Application number: 2026/91547	
What is the application for?:	Change of use of residential dwelling (Use Class C3) to childrens care home for
Address of the site or building:	28, Sylvan Ridge, Huddersfield, HD2 1ZH
Postcode:	HD2 1ZH

Type of comment: An objection	
Do you wish your comments to be published on the website anonymously?	Yes
Application No: 2026/91547 this document created 1st July 2026 Case Officer: Danielle Cooper Applicant: S Yousaf List of Planning Objections and Representations to the proposed change of use to number 28 Sylvan Ridge HD2 1ZH from its current residential use (class C3) to a residential Care Home for up to two children (class C2) and external alterations to form additional parking area. I wish to object the planning application No. 2026/91547 on the following grounds. 1) I object because the applicant has not demonstrated that 28 Sylvan Ridge is a safe and suitable location for vulnerable children. The recent Inspector's dismissal of the children's-home appeal at 2 Robin Hood Road (also located on our housing estate) identified serious deficiencies in site-specific safeguarding evidence. I propose the applicant provide an Impact Risk Assessment on the

1st Floor

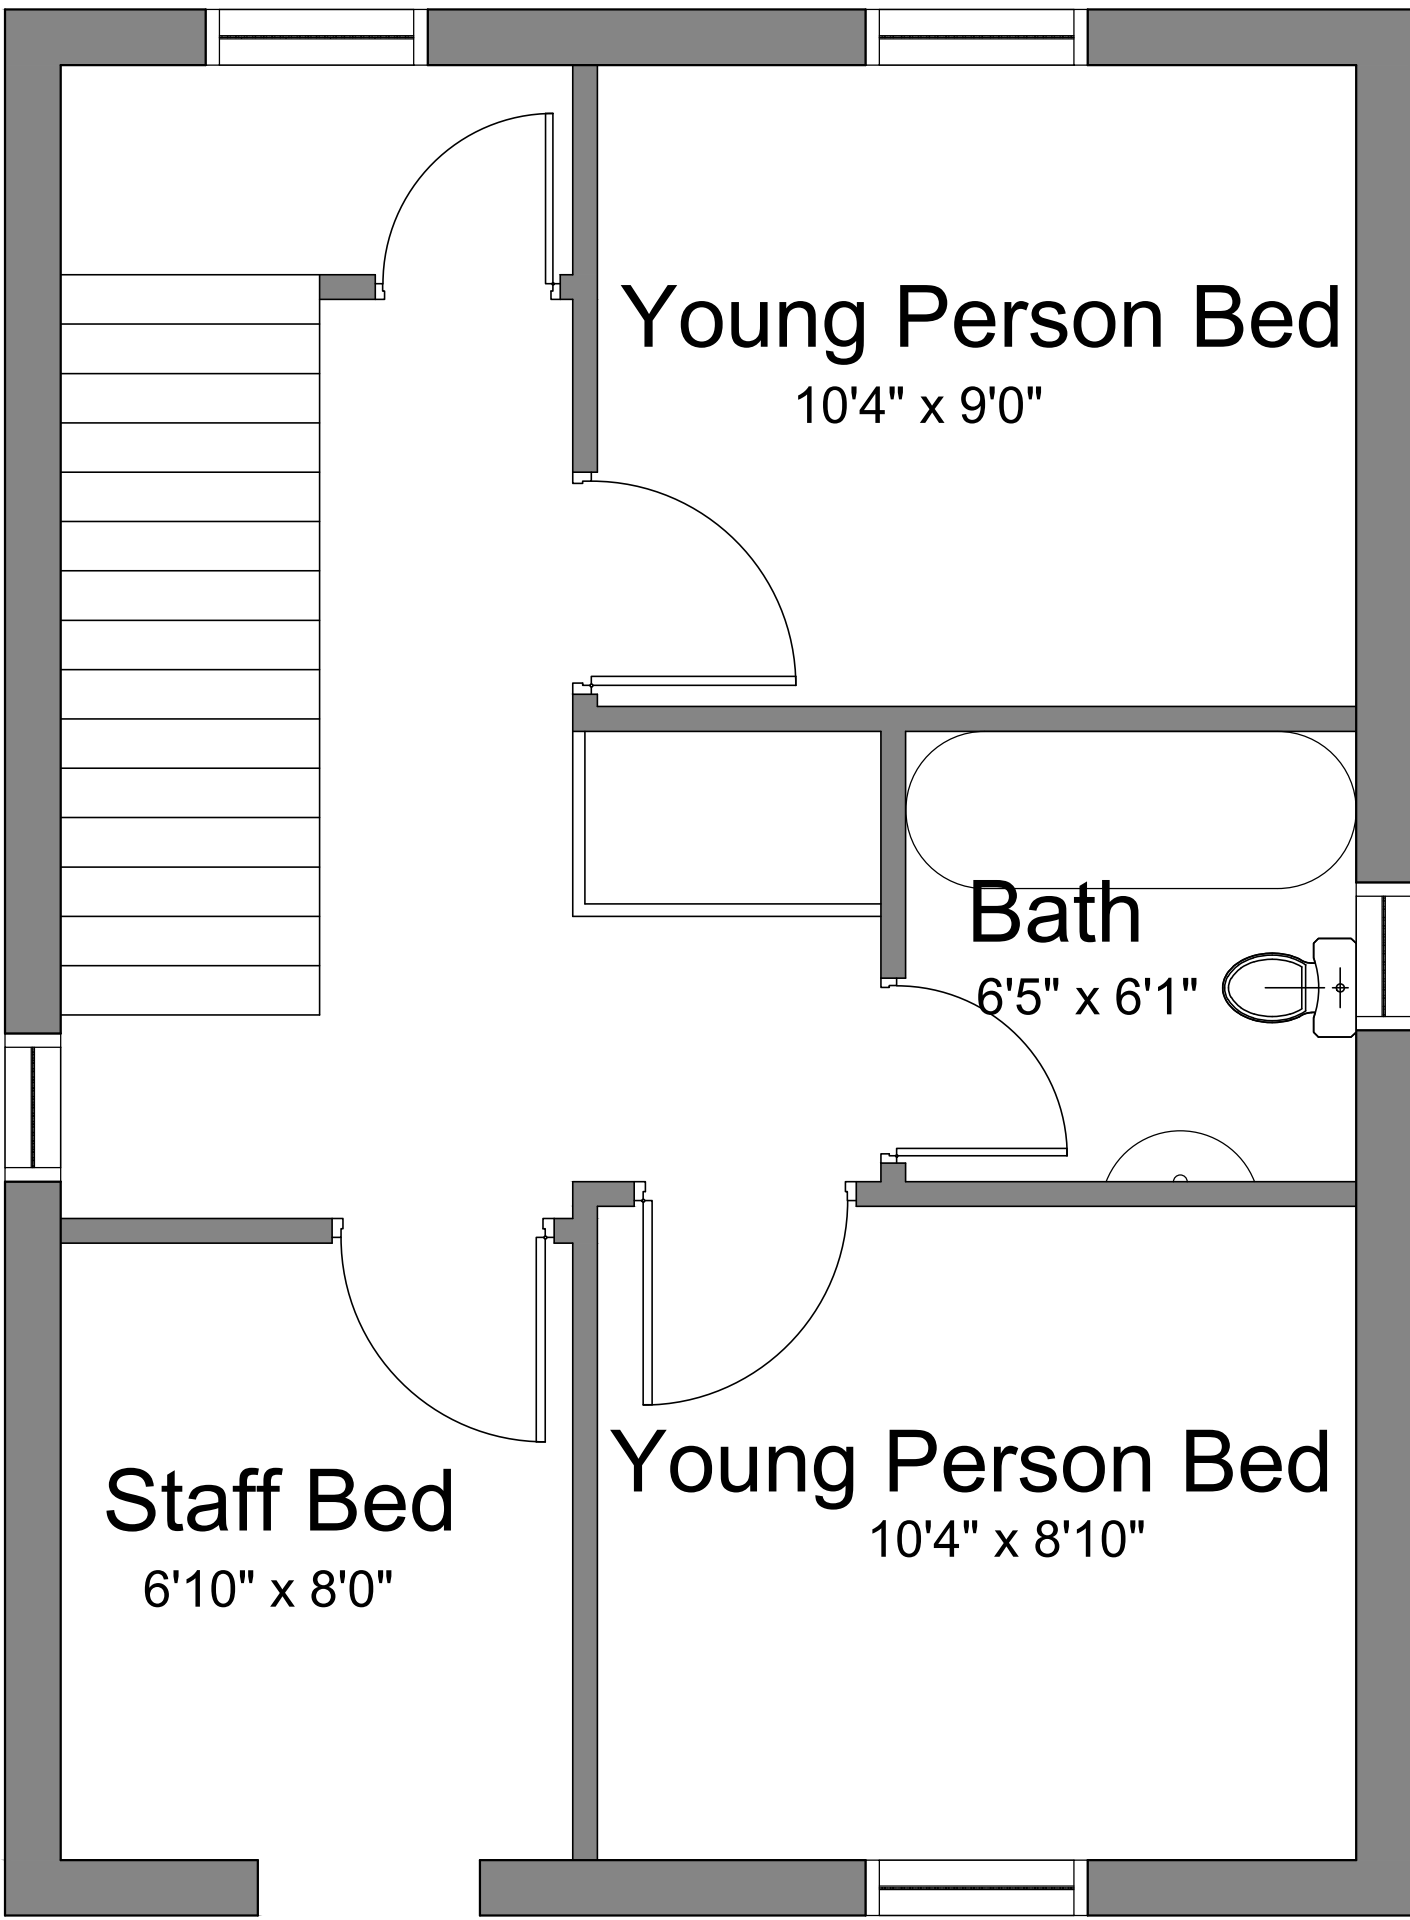
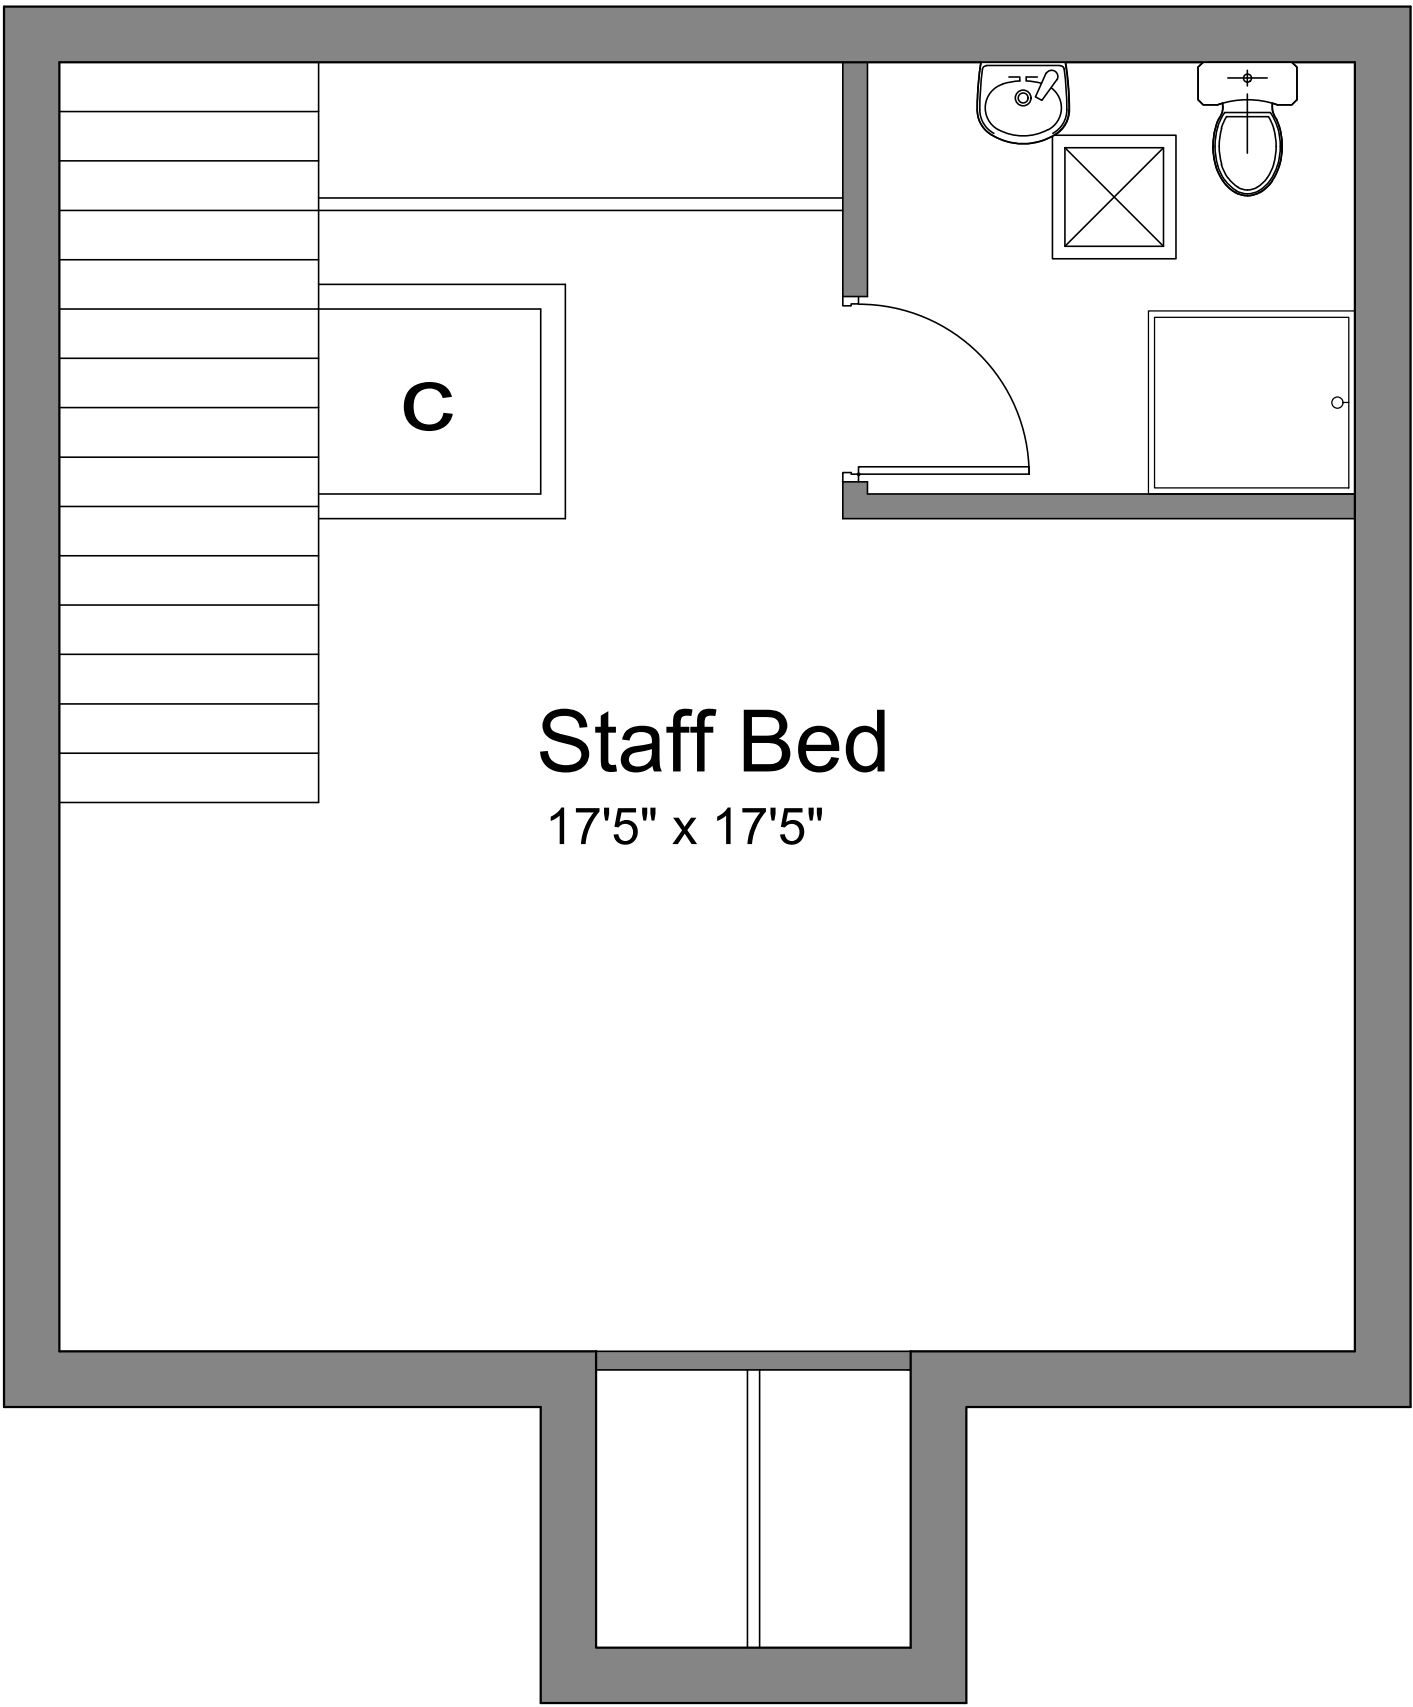
4) Staffing requirements. There are inadequate details of staffing, the plan submitted merely identifying the provision of two staff bedrooms. Further details should be submitted namely the number of staff to be employed, their qualifications, their rota and shift patterns plus managerial staff. Provision for cleaning the premises and cooking the meals. This would help establish the intended seriousness of the application to the surrounding residents.

BLOCK PLAN

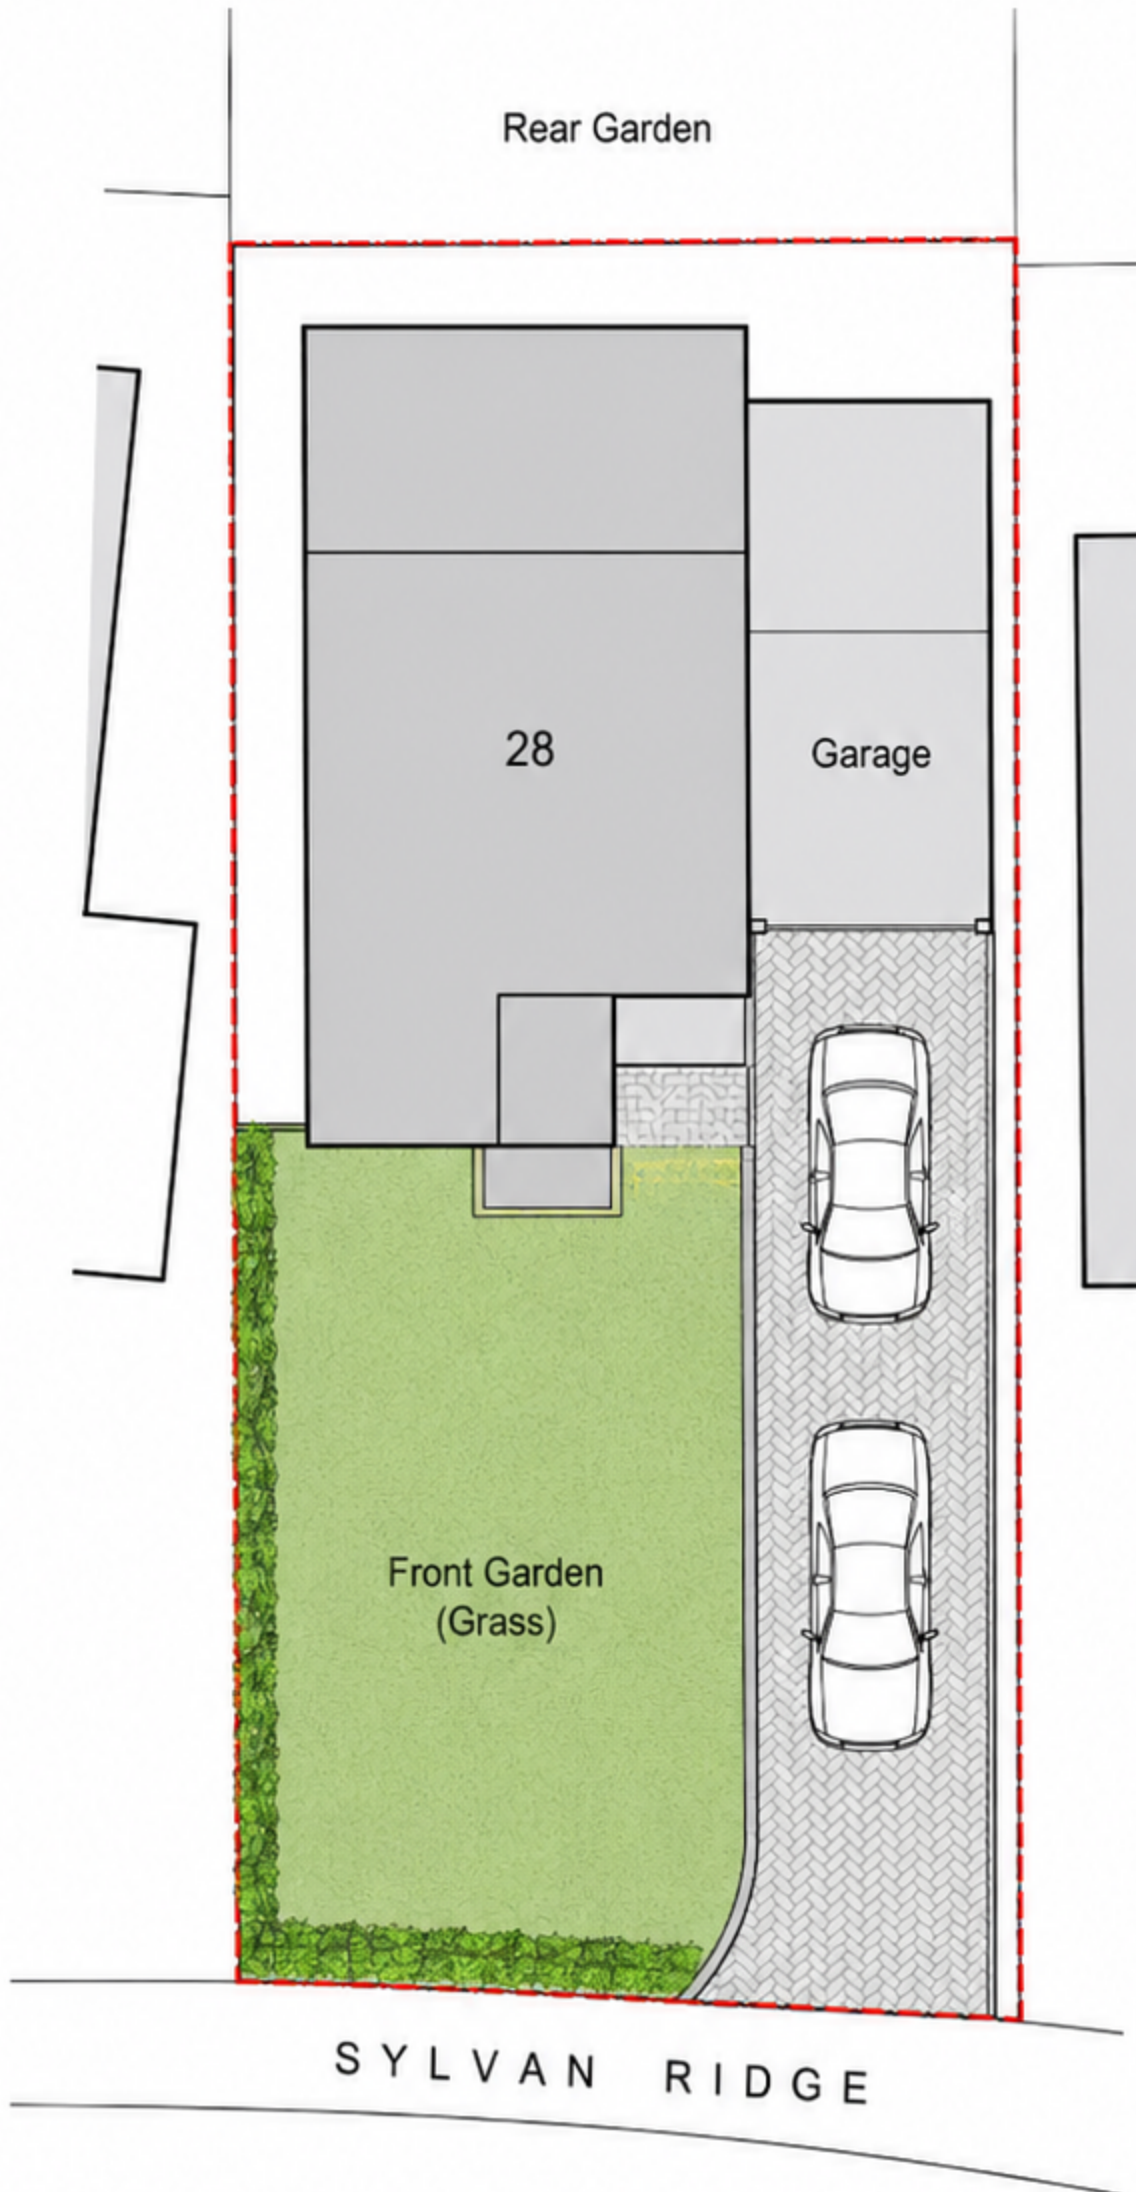
accessing the rear of the property for car parking. There is a single width drive at the front which fits 2 cars one behind the other. This is shown on the block plan provided by the Applicant. The only way to increase off-street parking is to hard-surface the existing grass lawn to the left of the drive. The Applicant has applied for separate planning permission to do this. The Applicant's block plan is very misleading in that the lawn is shown much bigger than it is in reality. The lawn is drawn at double the width of the adjacent drive implying there is plenty room to create two more car parking spaces. Site measurements establish the drive is 2.80 metres wide but the lawn next to it is only 2.30 metres wide. If the original planners determined a width of 2.80 metres was necessary to allow the unrestricted opening of the car doors on both sides of the car, then is 2.30 metres too narrow a width? The Applicant should provide a fully dimensioned drawn to scale block plan to illustrate the actual size width of the lawn in contrast to the existing width of the drive. Further details of the conversion of the lawn to a car park should be submitted to planning. These include the type of surface material to be used, is it permeable, are extra water run-off drains to be installed, the amount of landscaping that would be removed or retained specifically the mature hedge forming the left-hand boundary of the lawn.
